Submission

Applicant – Bowden’s Silver Pty Ltd
Application Number – SSD- 5765
Application – Bowden’s Silver Mine

Figure 5.1
LOCAL SETTING

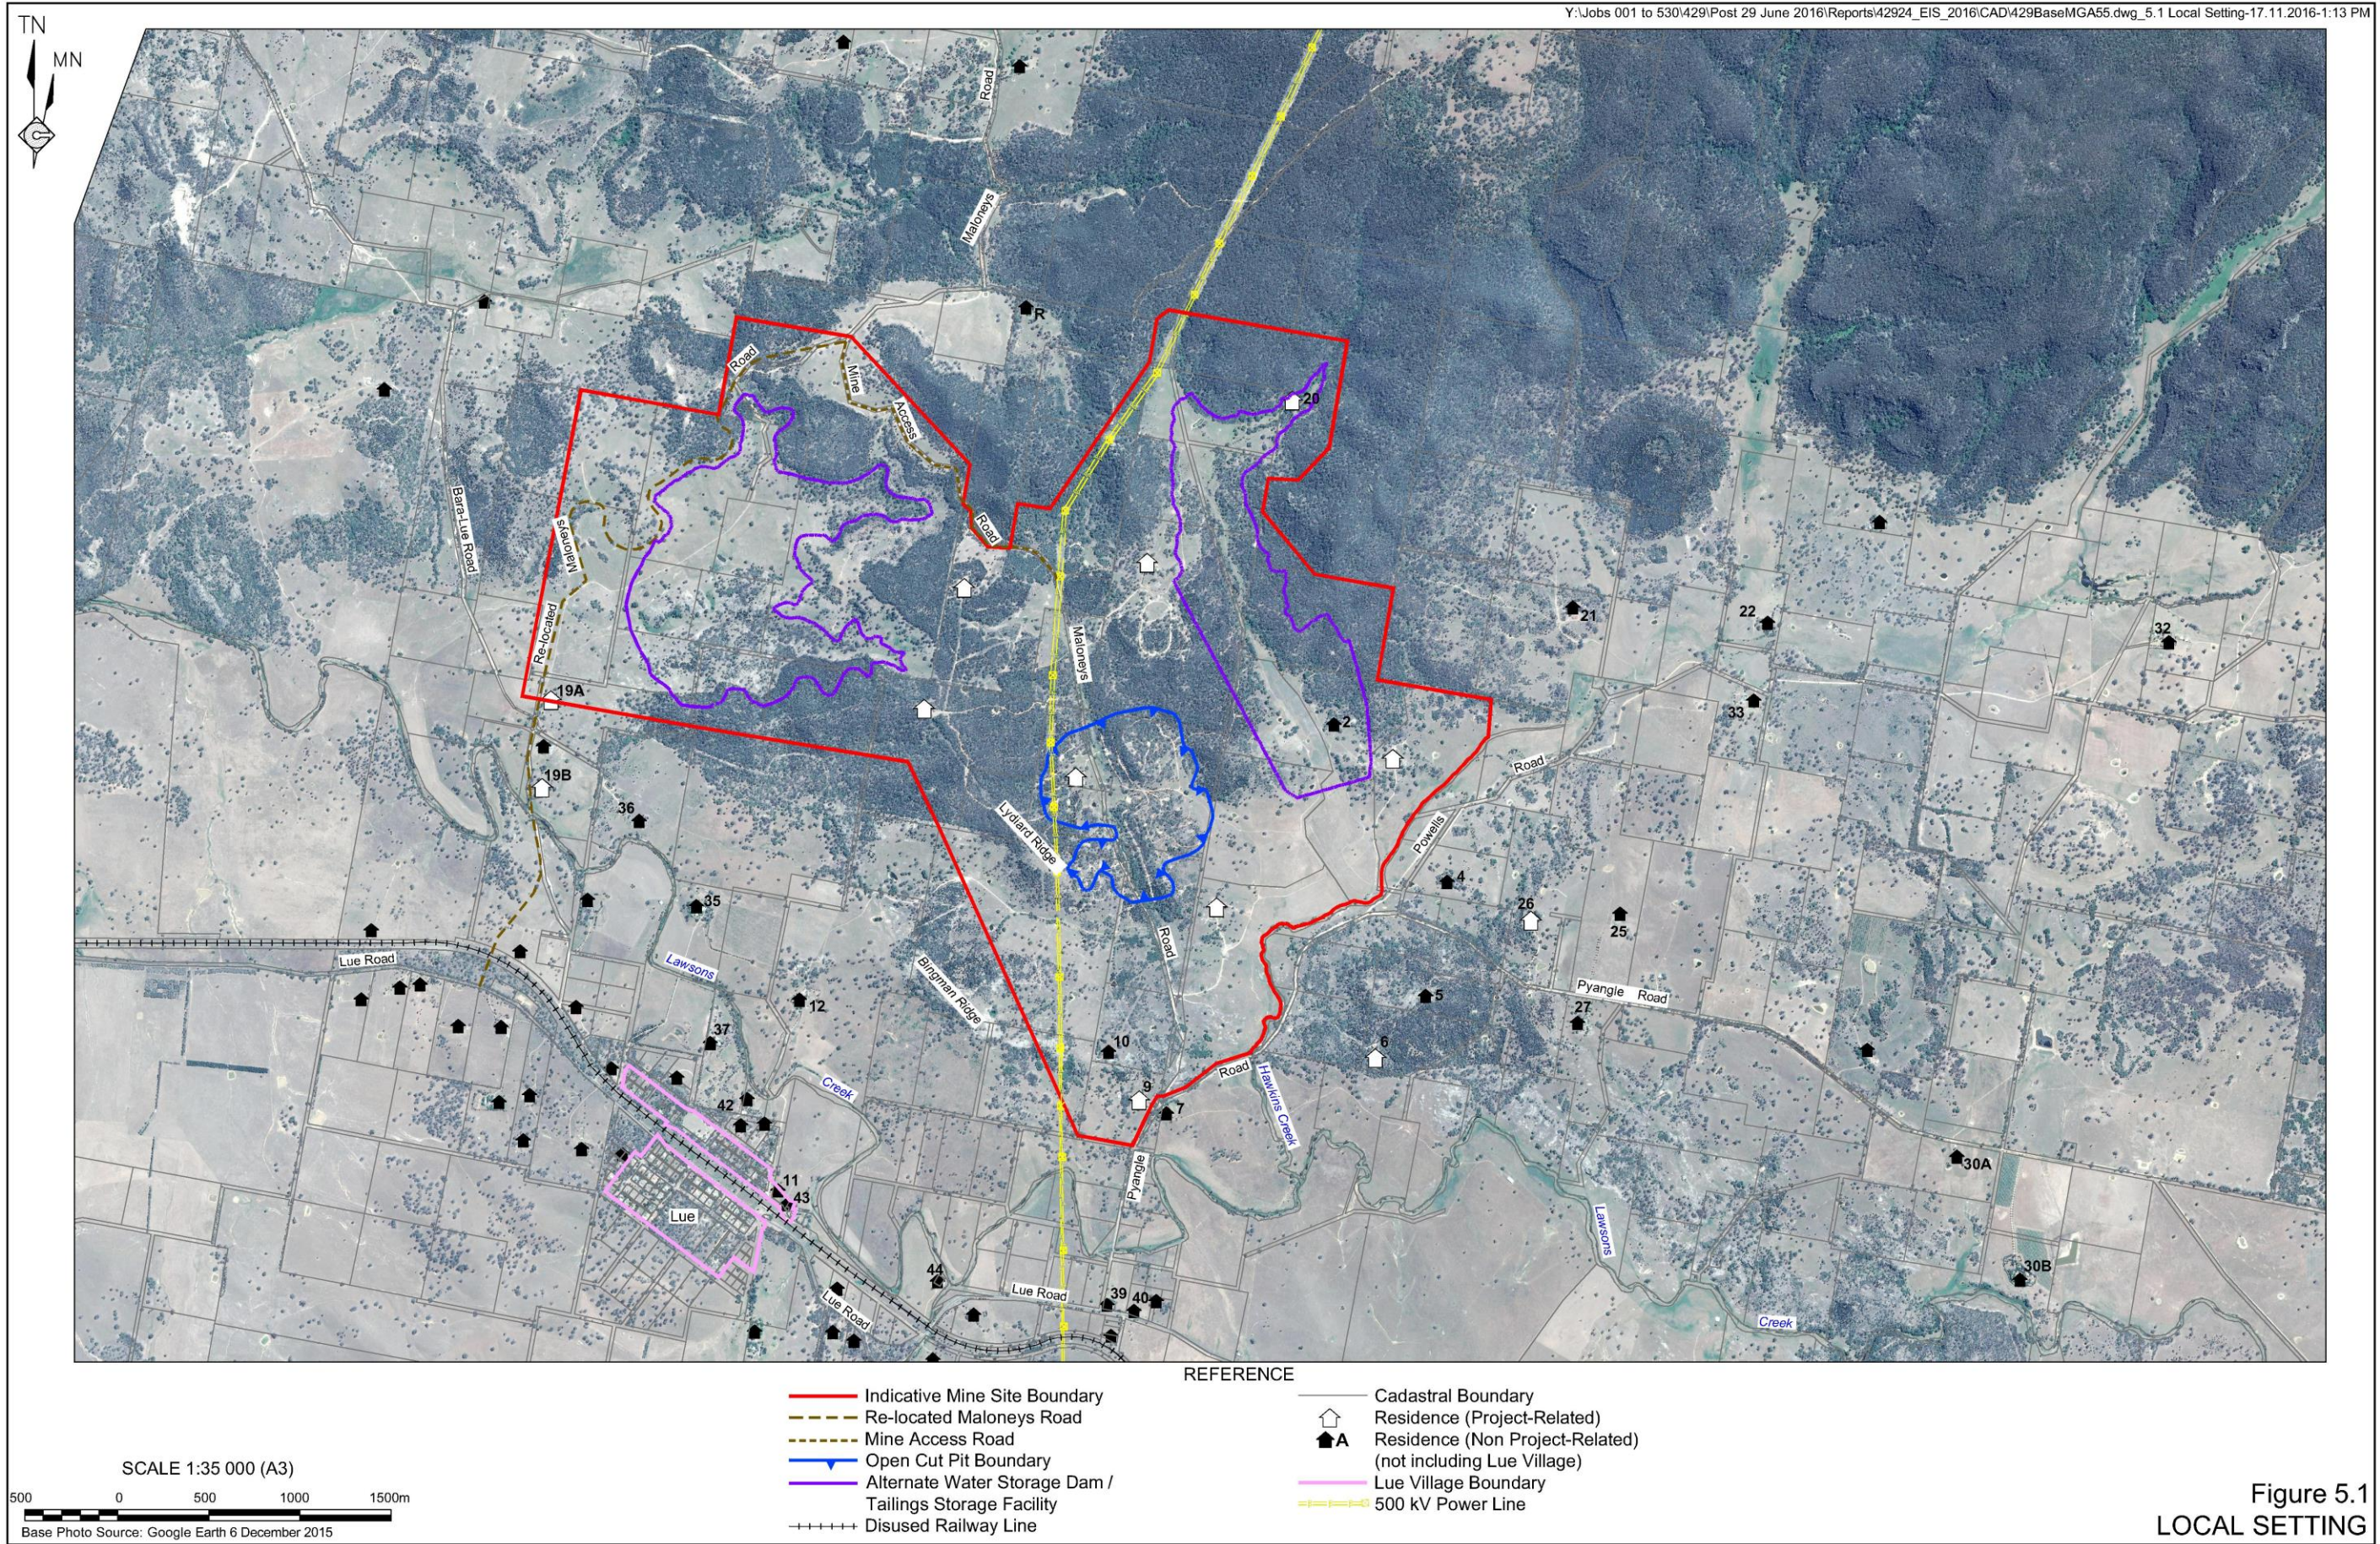
Bentivoglio Olives are immediate neighbours of Bowden's mine located in Monivae and classified as part of the district of Lue. Bowden's totally disregard our olive grove by not even placing our grove and facilities on their maps, see Fig 1.2 Local Setting plan.

they cover us up with a reference chart.

DPIE has no direct view of how close we are to the mine and therefore DPIE are not made aware by Bowden's that we even exist within 4-6km and as residing in Monivae and in the district of Lue.
